# CITY OF ALBUQUERQUE

July 21, 2008

RE: **APS – School on Wheels at Chaparral Elementary** (F10 – D 005 A)  
**Drainage Plan for Building Permit** (PE Stamped 6/12/08)

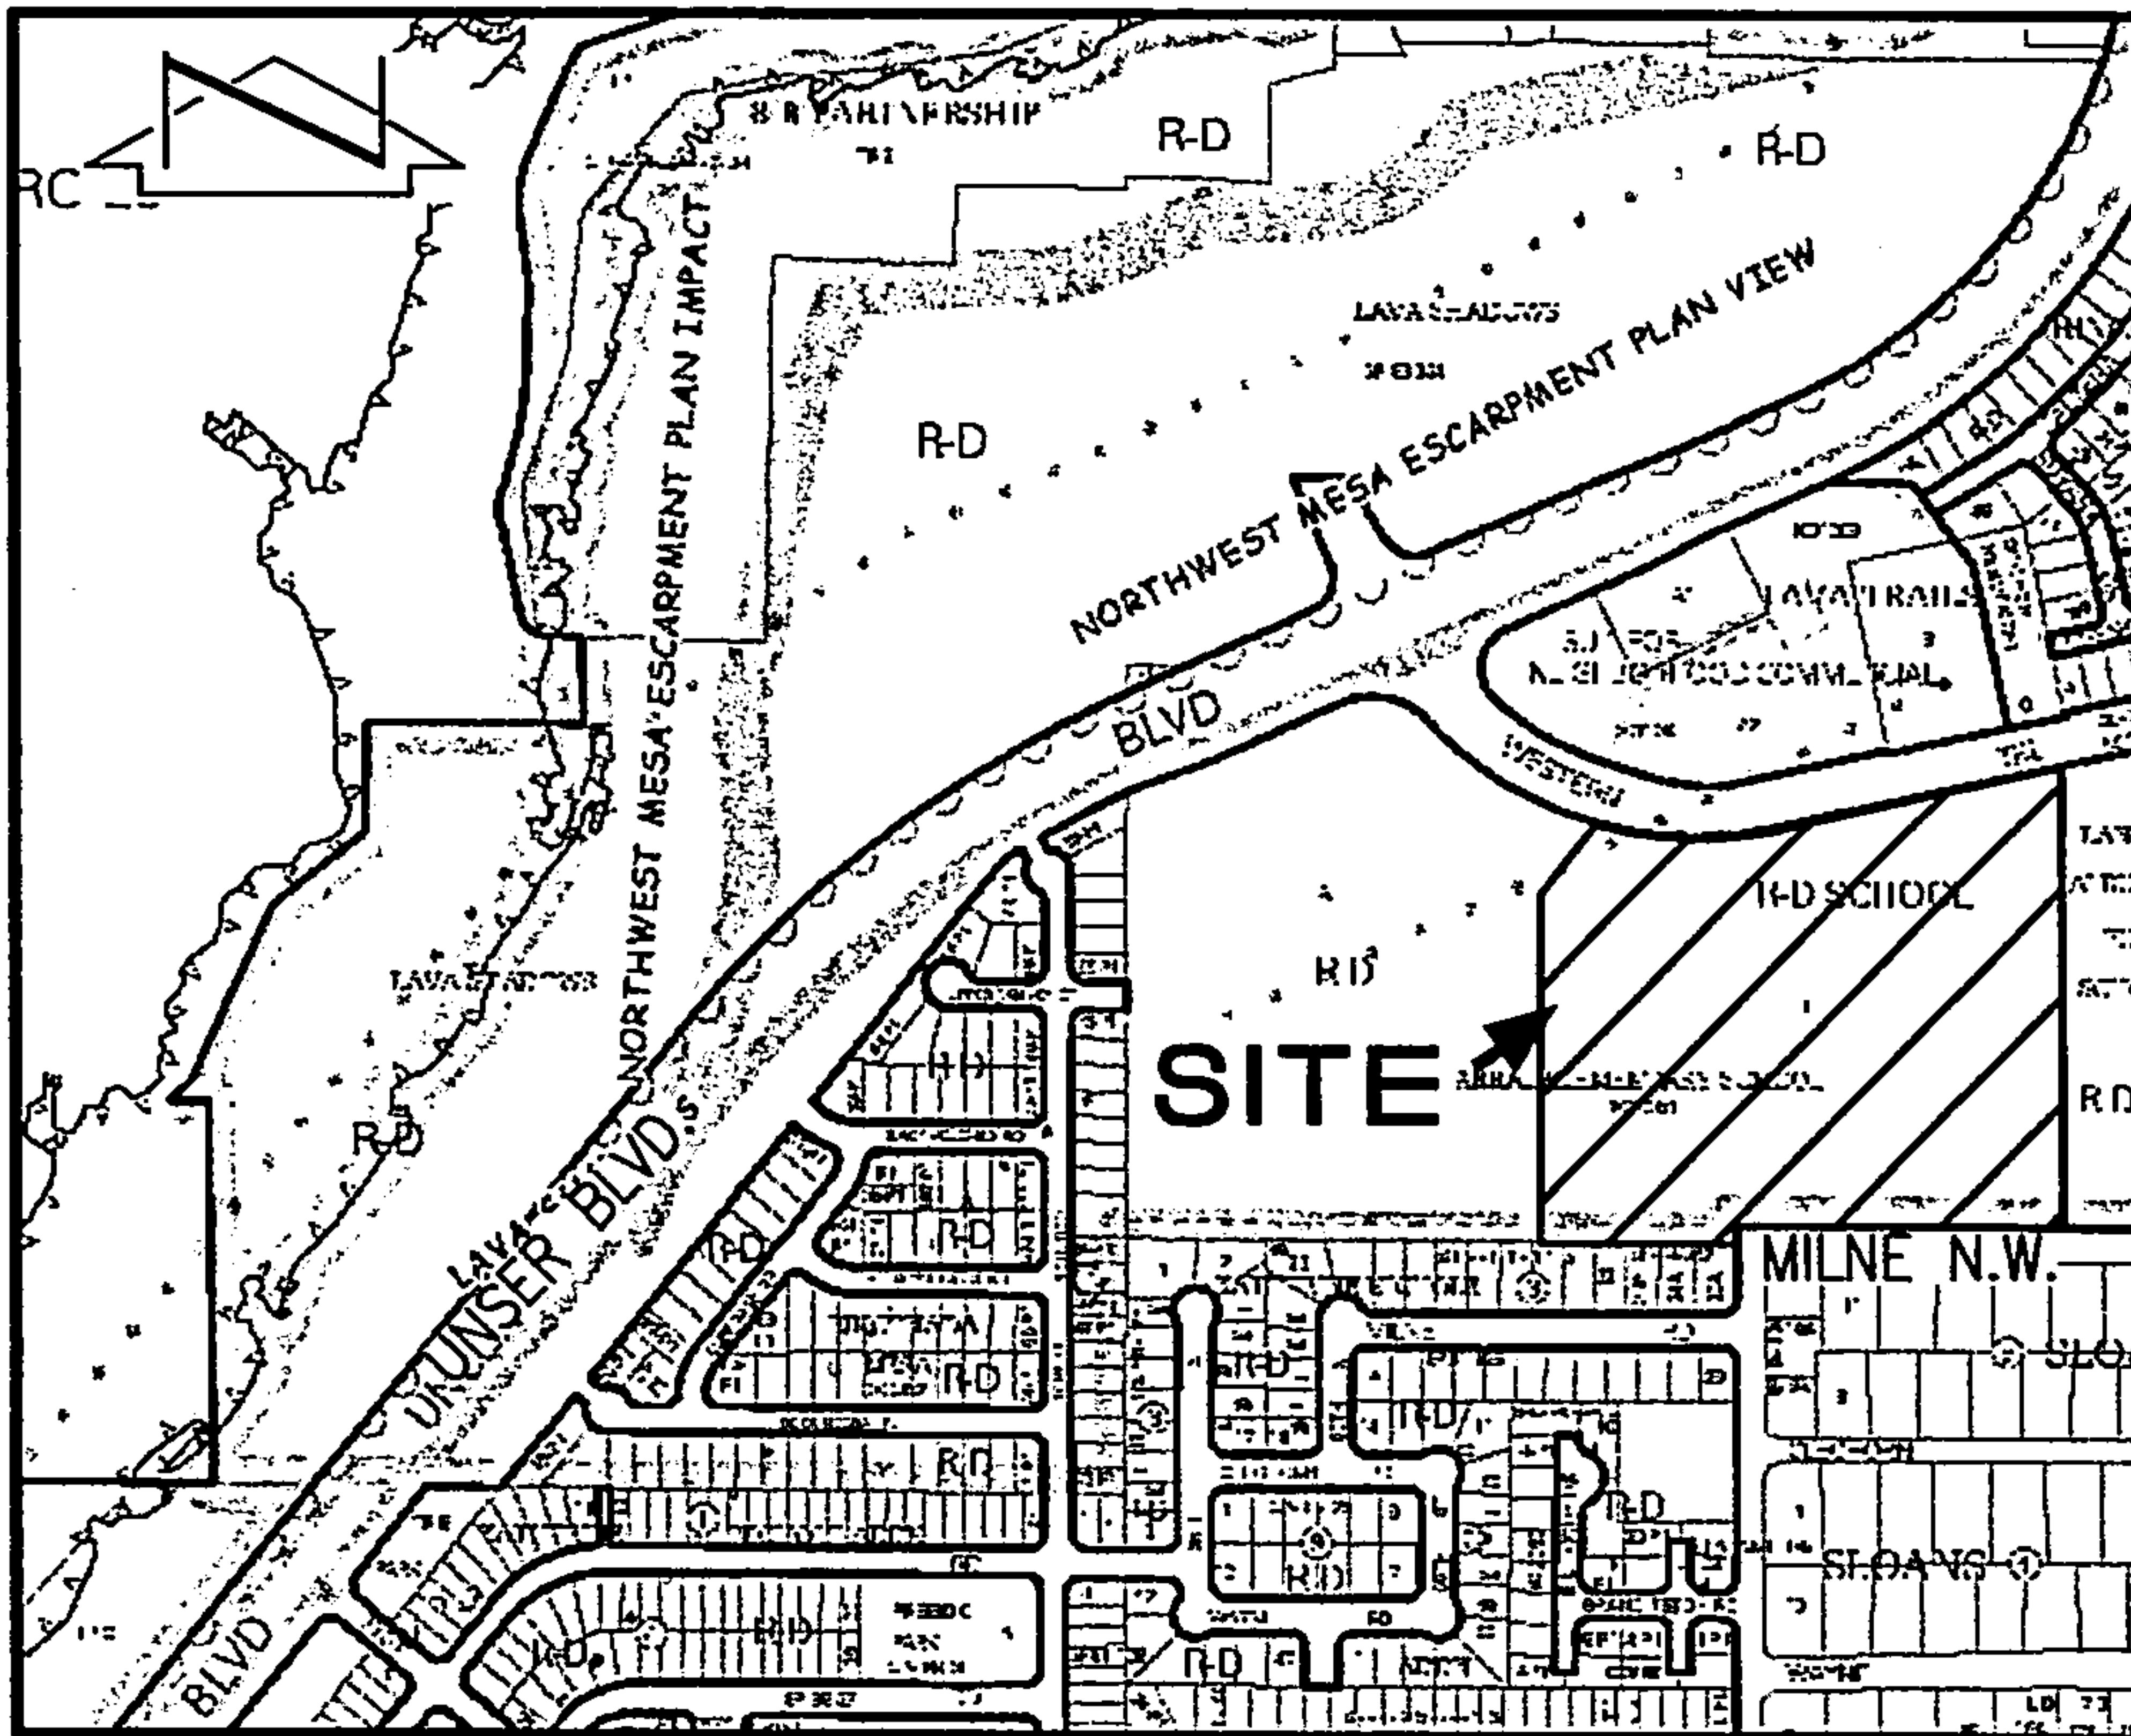
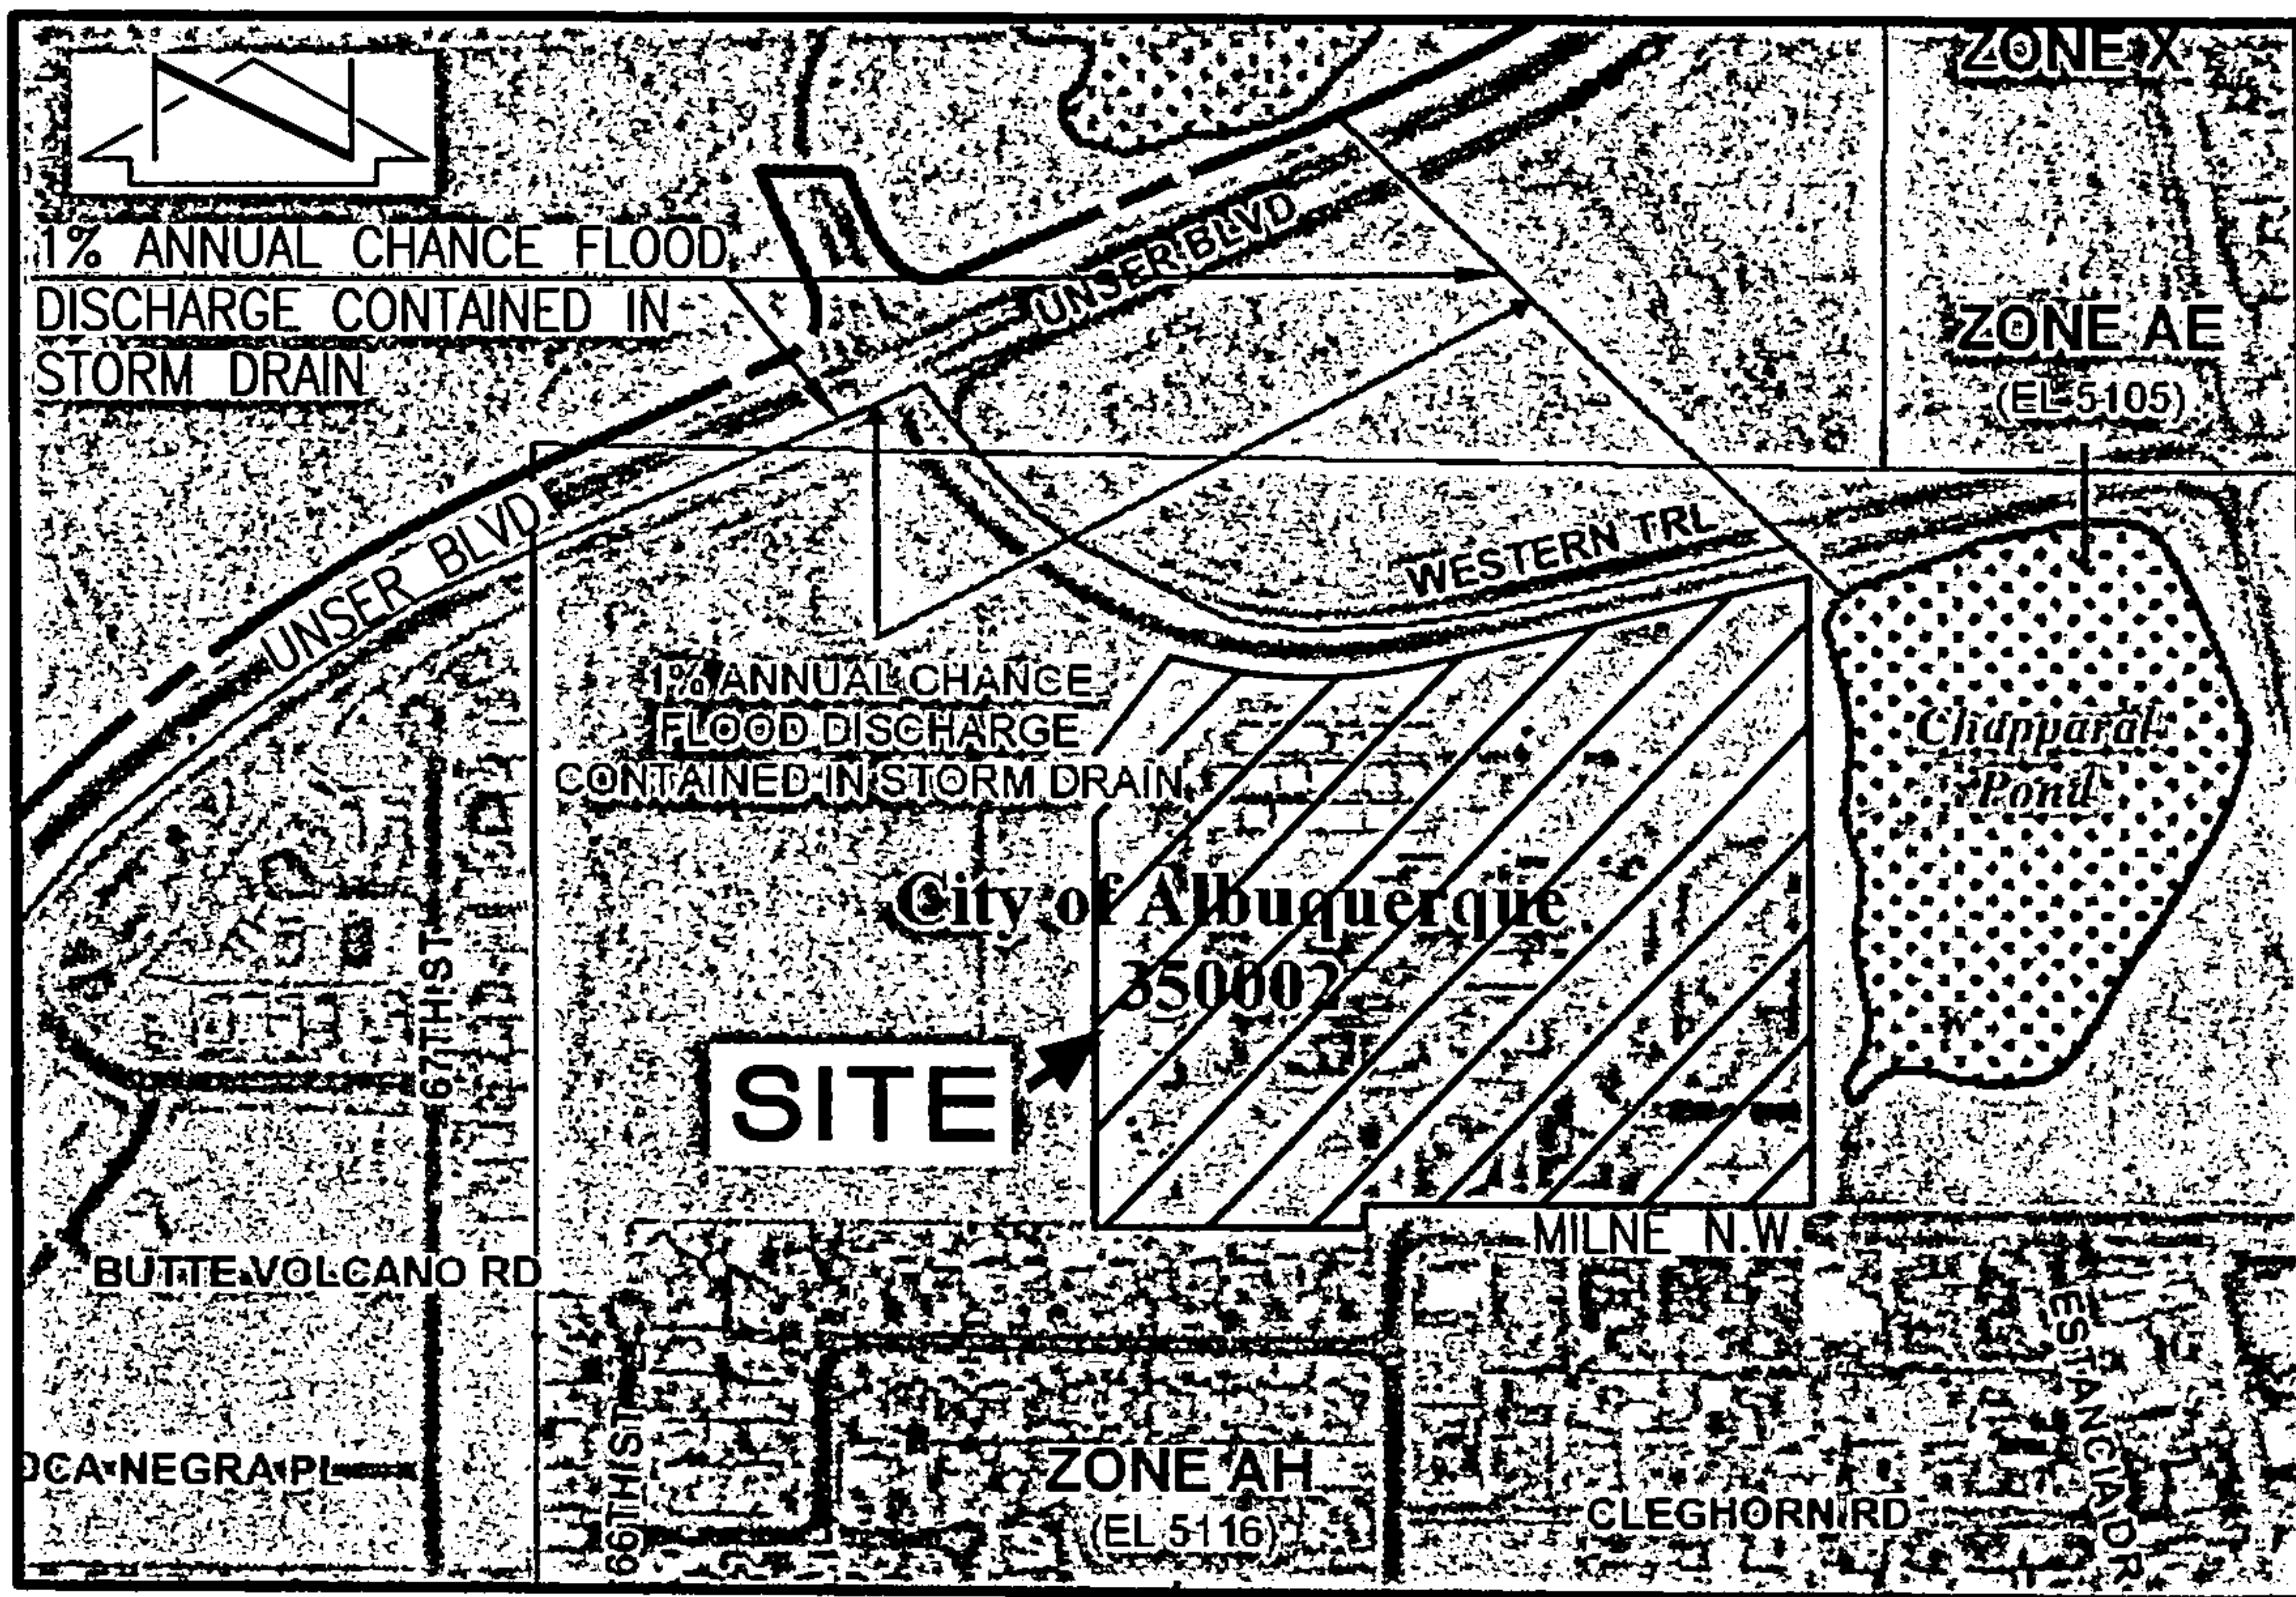
- 1 ) **CD1:** The drainage analysis seems to overlook the fact that approximately 40% of Basin #1 drains into the west and south sides of Basin #2. Review and revise grading and pond calculations accordingly.

- 2 ) **CD1:** Show on the Site Drainage Plan the existing flow pattern along the eastern edge of Basin #1. Quantify that flow and indicate on the plan where it crosses into the east end of Basin #2, and how that flow is intercepted and conveyed through the pond and storm drain system at the School on Wheels site.

- 3 ) **CD1:** Label the existing Storm Drain along the eastern edge of Tract A, and indicate any inlets which may exist and divert site flows.
- 4 ) **CD1:** Show what grading will be done in the proposed decommissioning and relocation of the existing Portable site at south east corner of Tract A.

- 5 ) **CD.2:** Provide invert elevations on inlets, outlets, and manholes on the proposed storm drain lines, and at the existing 36" RCP storm drain stubout to the site.

- 6 ) **CD.2:** Show elevations on the existing contours that intersect the site perimeter.
- 7 ) **CD.2:** The proposed "5112" contour on the west and north sides of the site does not work with the other contours, nor with the swale defined by spot elevations on the northern side of the portables. Does the swale continue around the west side of the portables? Clarify this configuration in conjunction with handling of off-site flows.

- 8 ) **CD.2:** Show on this plan the proposed access road paving and grades on the eastern edge of Basin #2.
